Re: Revisions to Planning Application for 68 The Drive Bognor Regis PO21 4DS

Please find enclosed 4 complete sets of the following revised plans:

Drg No
68/2014/40P

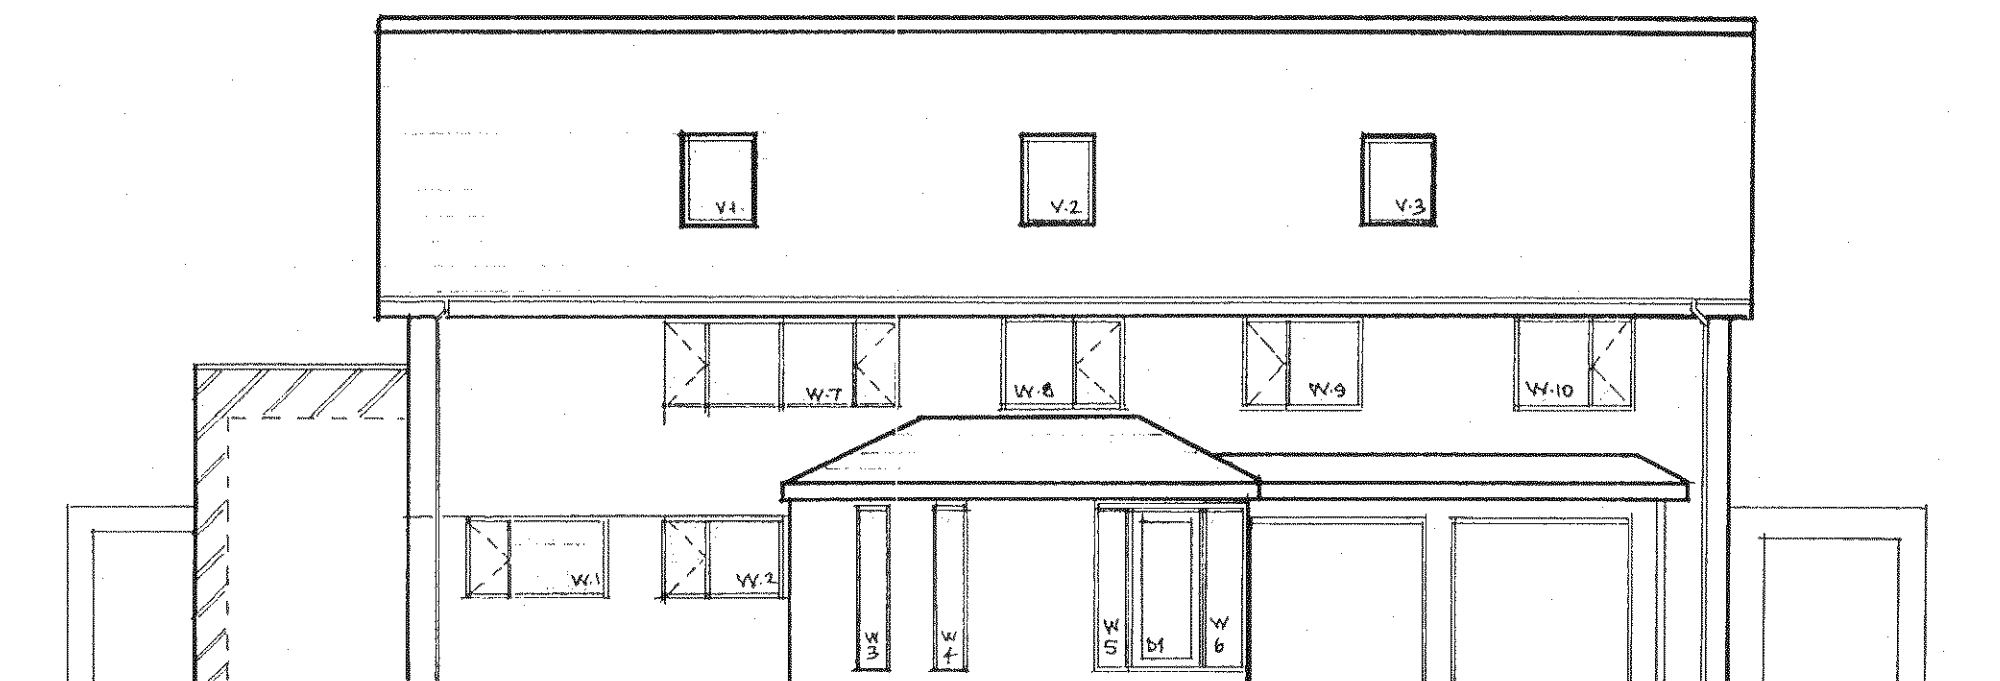
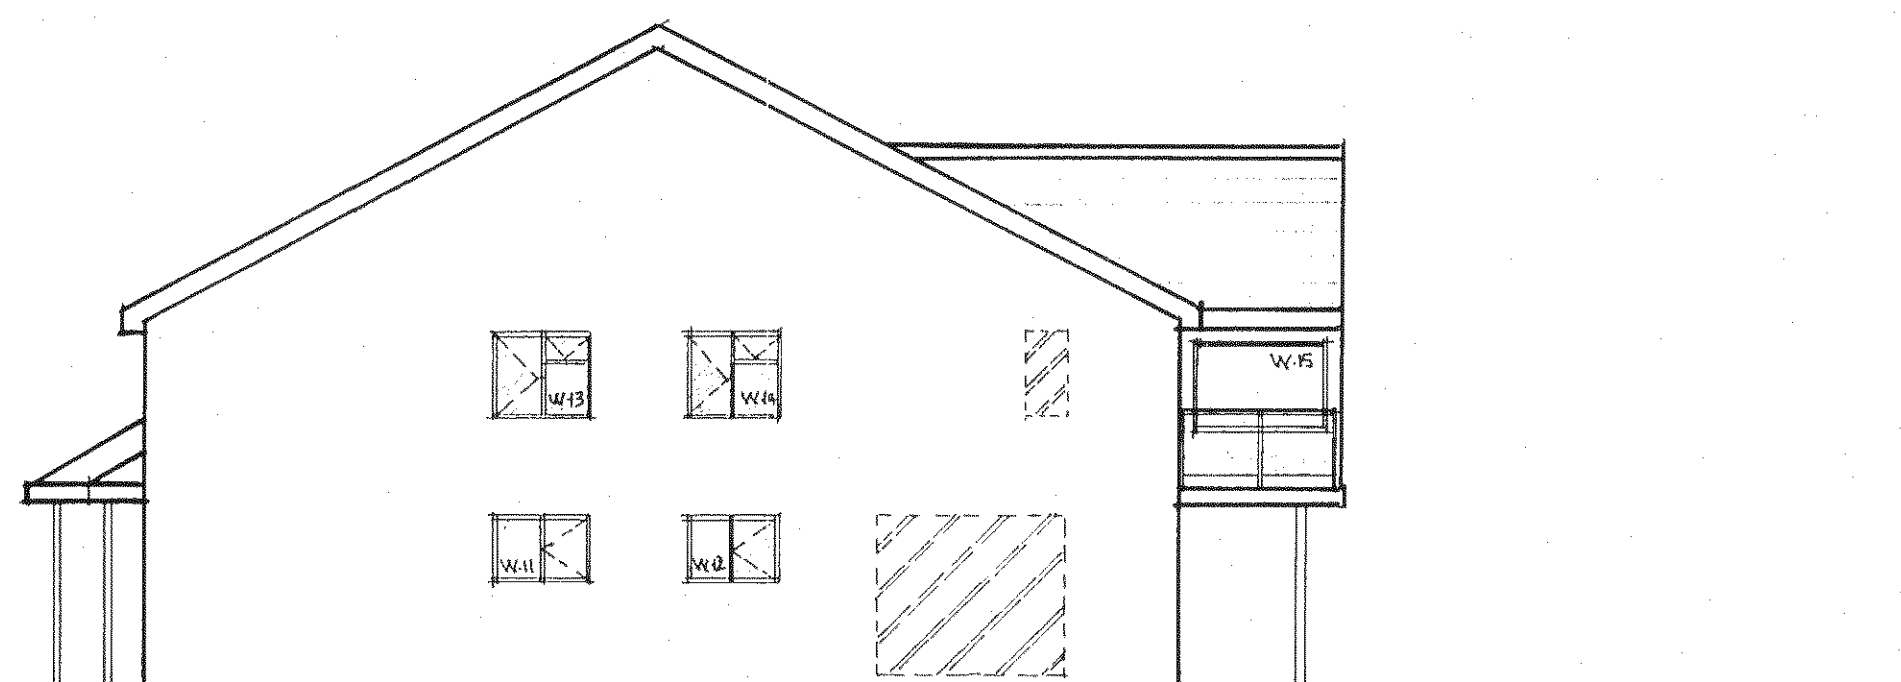
It is proposed that all external windows and doors where shown on the proposed elevations and identified by a reference prefix, "w" for windows and "D" for doors will be replaced. This was indicated previously on **Dwg 68/2014/40P Rev A** and in our covering letter of 23/12/2014.

68/2014/30P

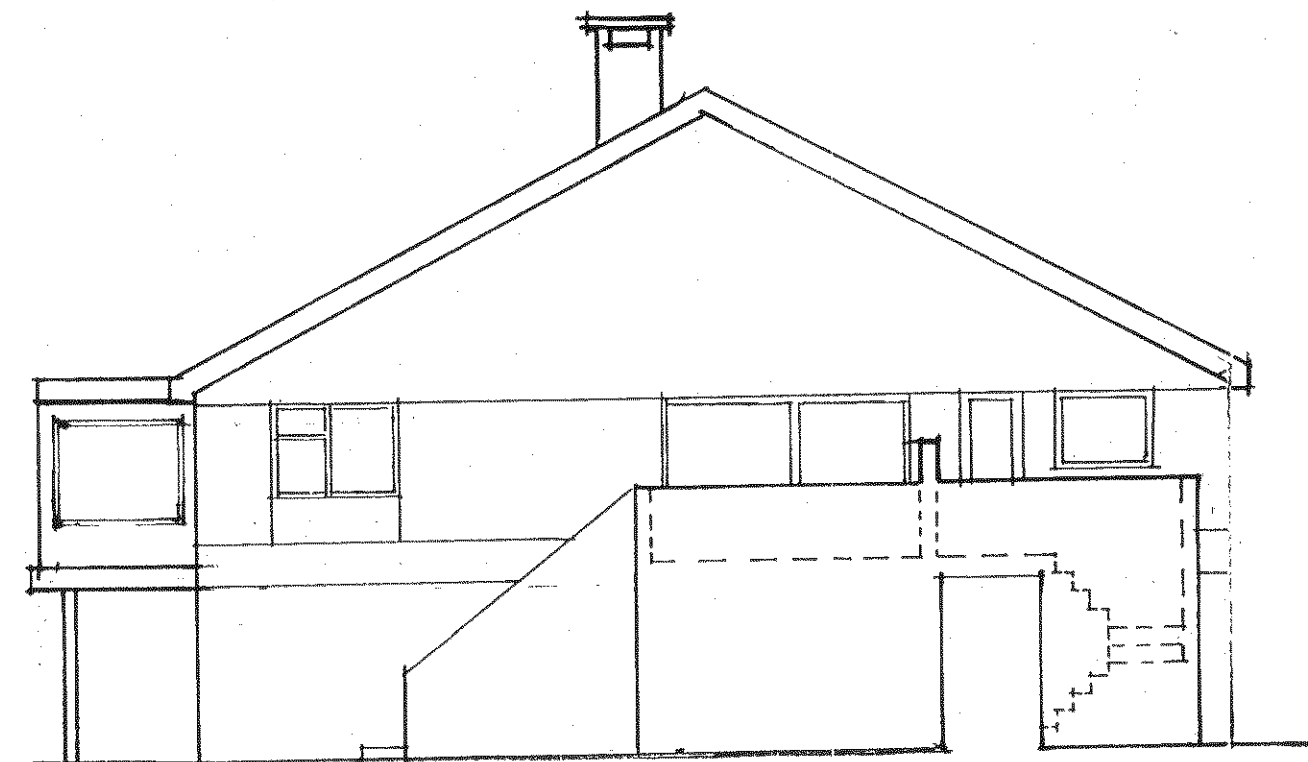
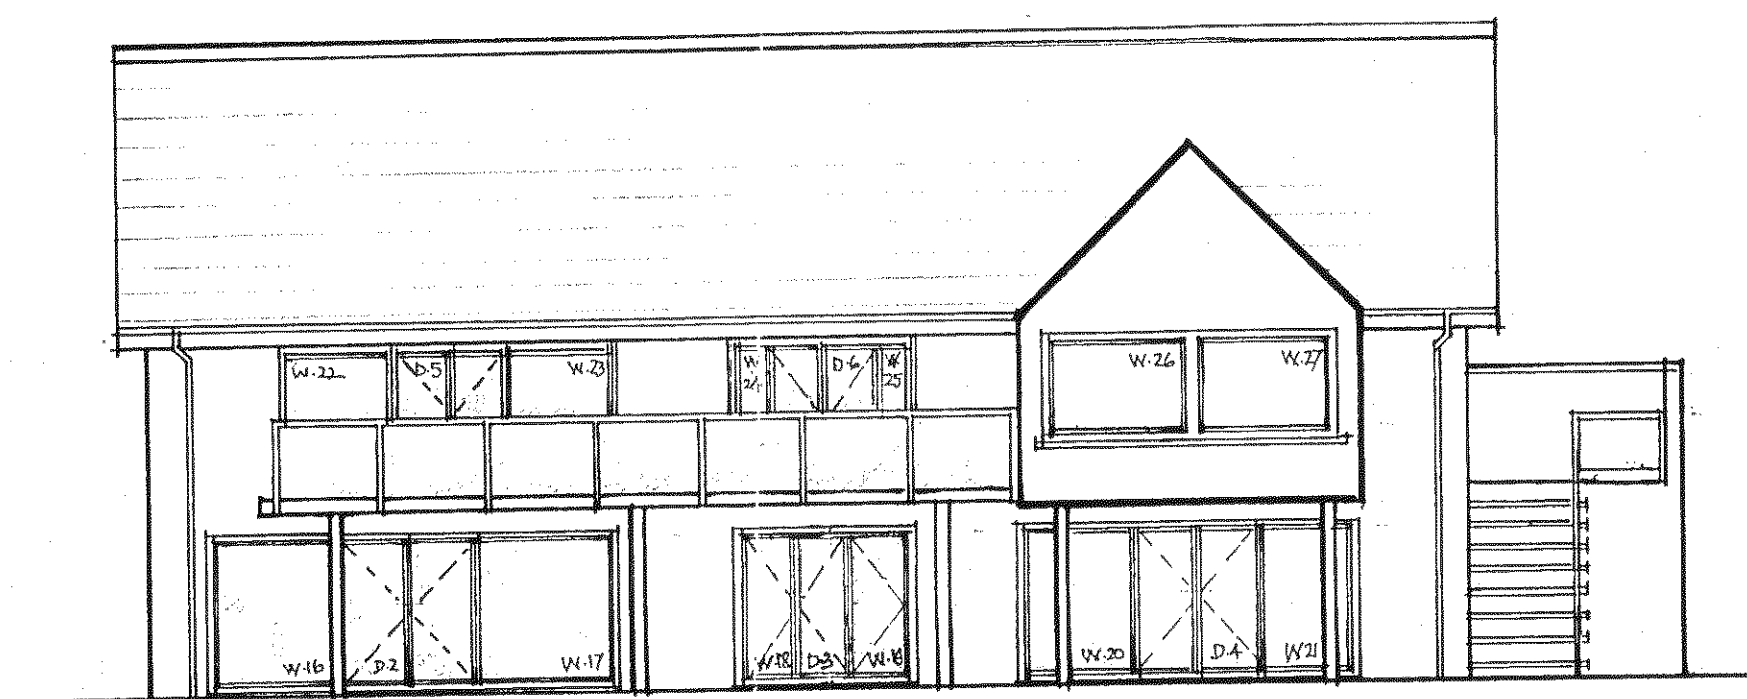
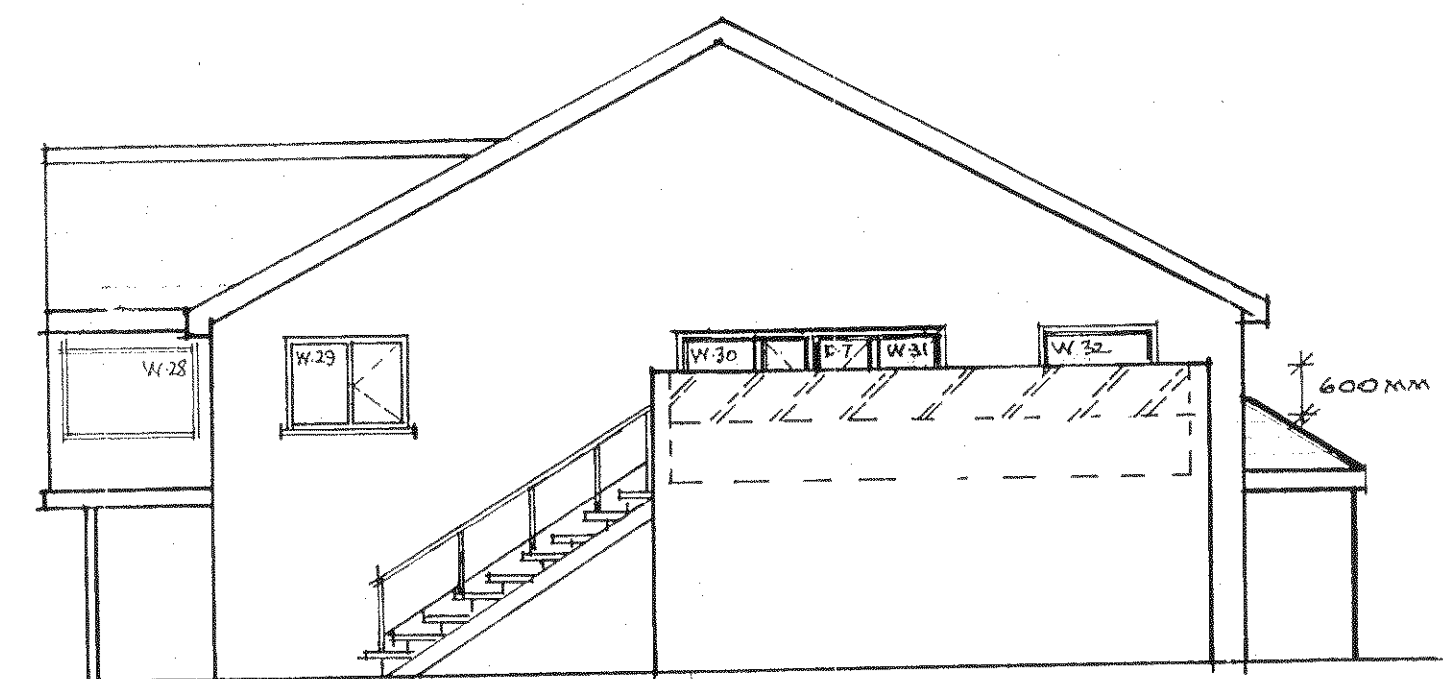
Dwg 68/2014/30P - Addition of the existing first floor extension to the East Elevation where not previously shown.

Drg No. 68/2014/1A.	Rev
------------------------	-----

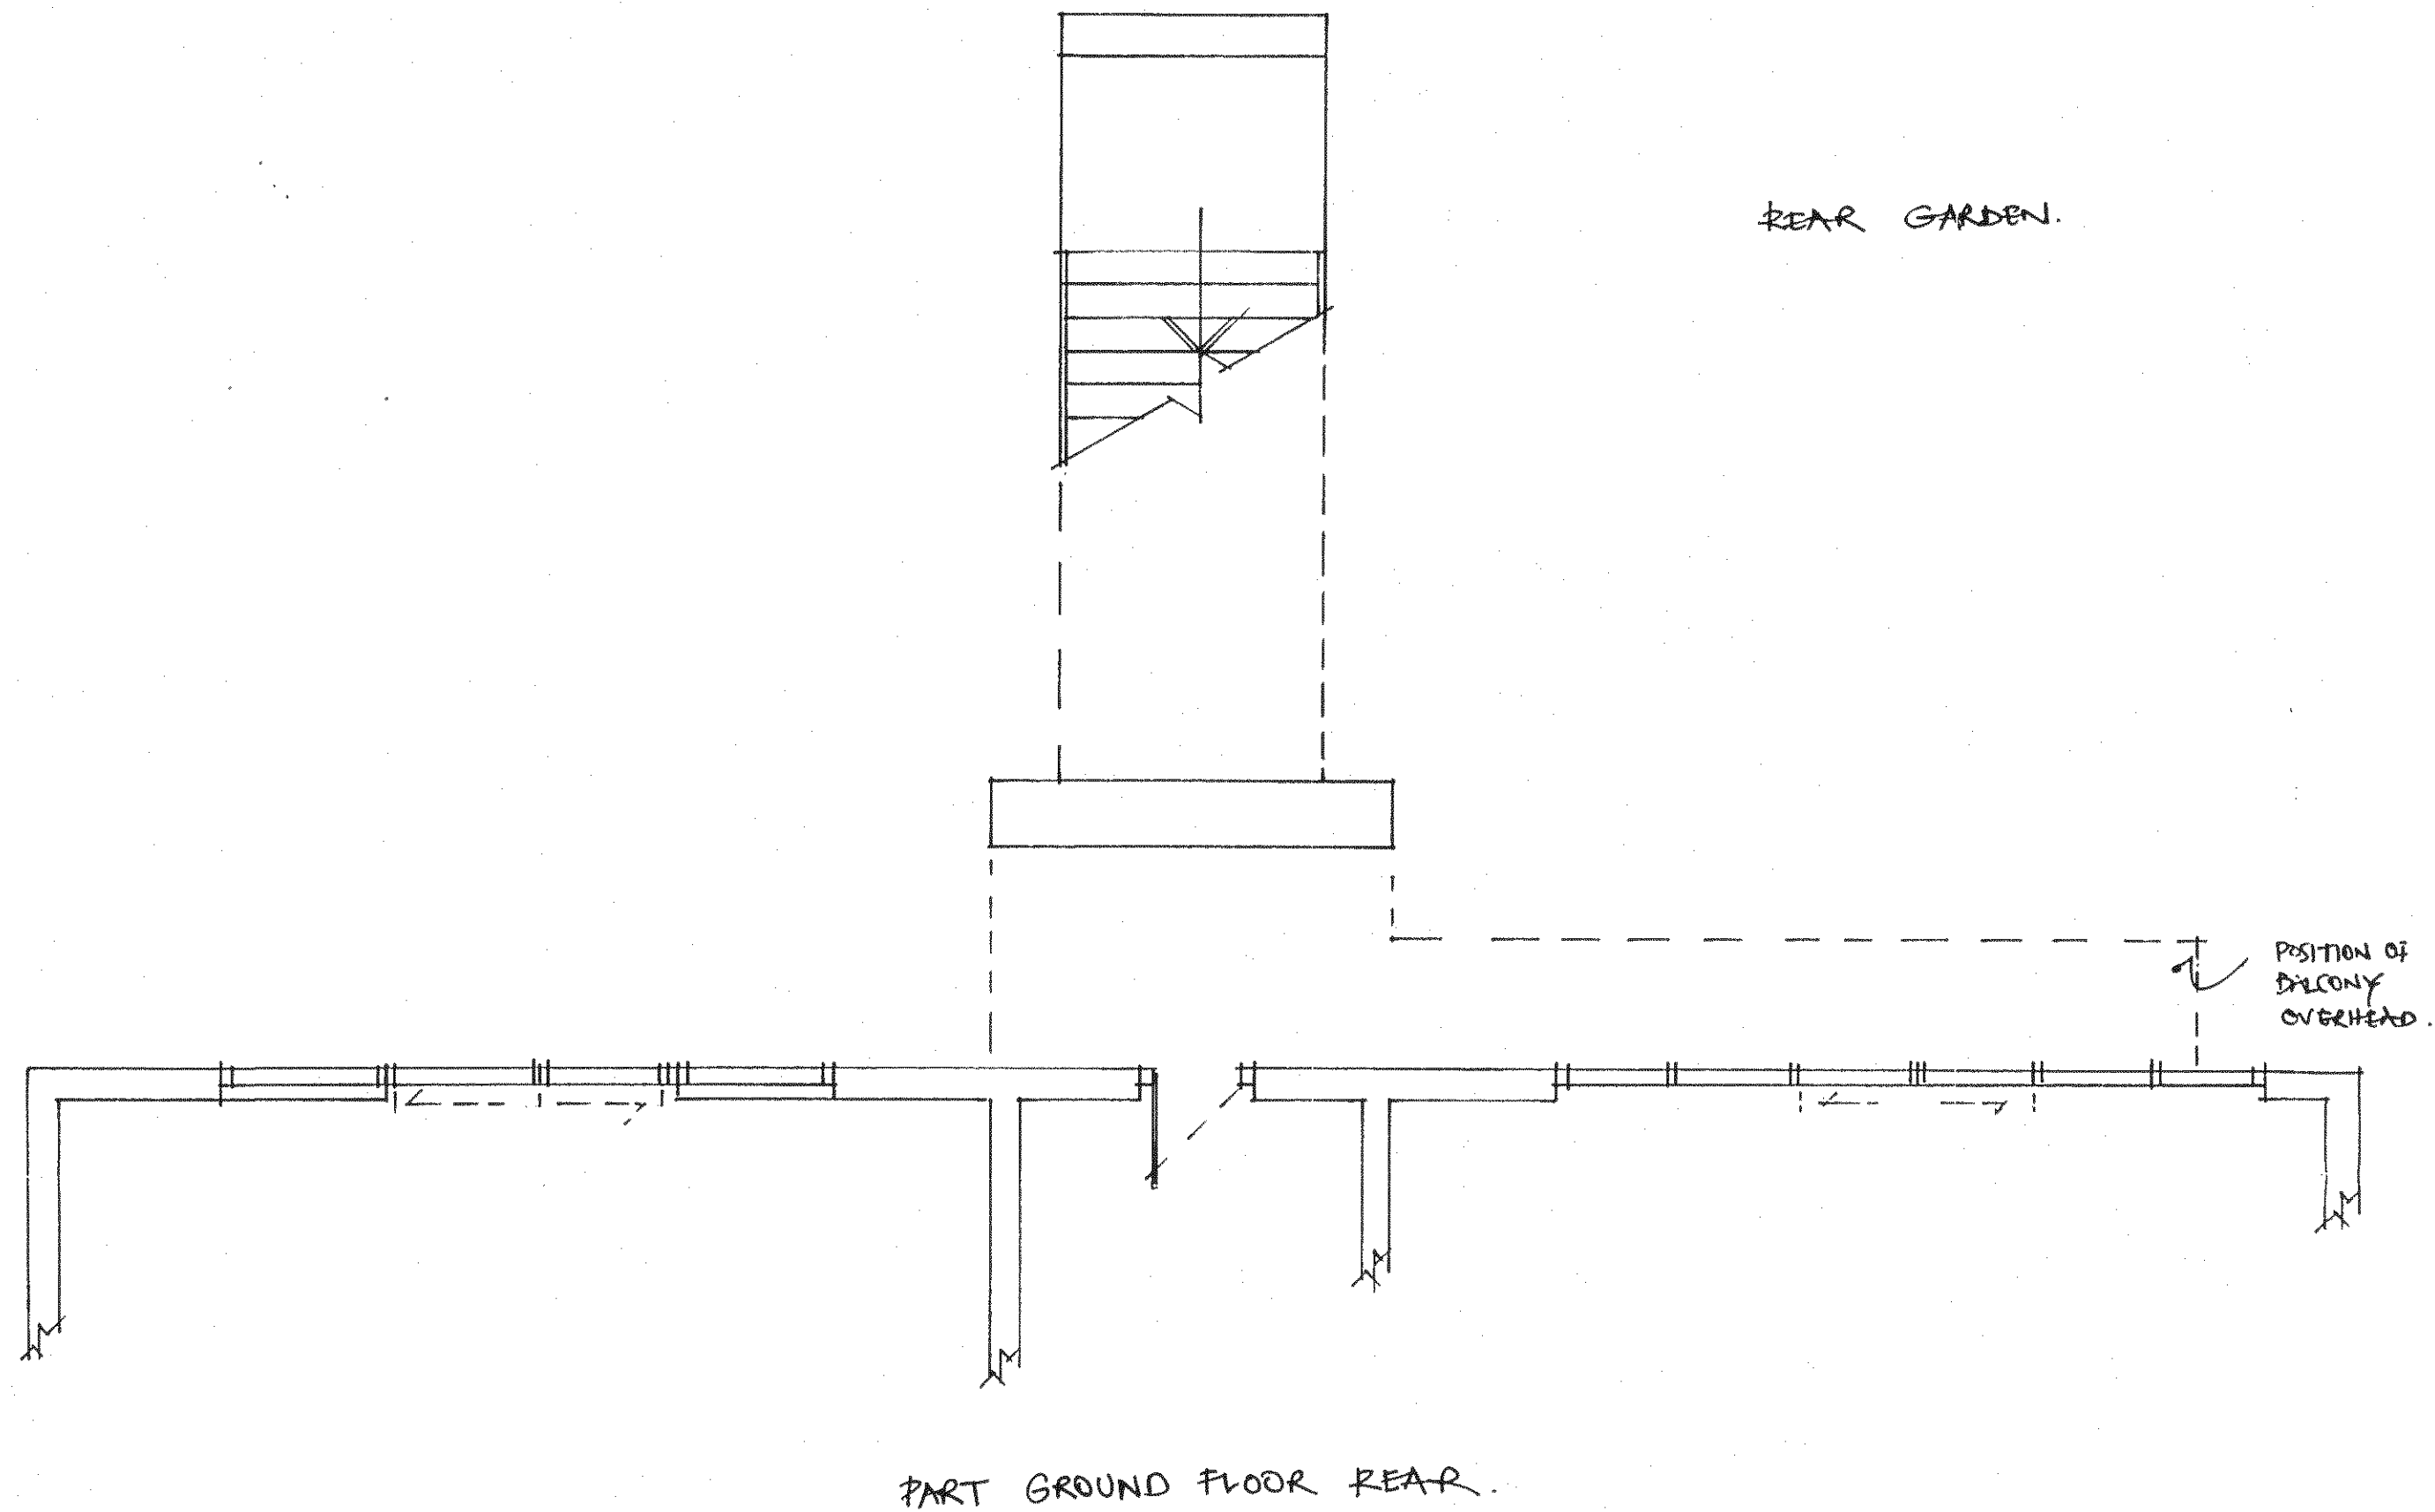
Dwg 68/2014/1 Rev B and Dwg 68/2014/1A - Showing the overhead location of the south elevation balcony and position of the steps at ground floor level. Both plans need to read in conjunction but now show the steps where previous omitted.
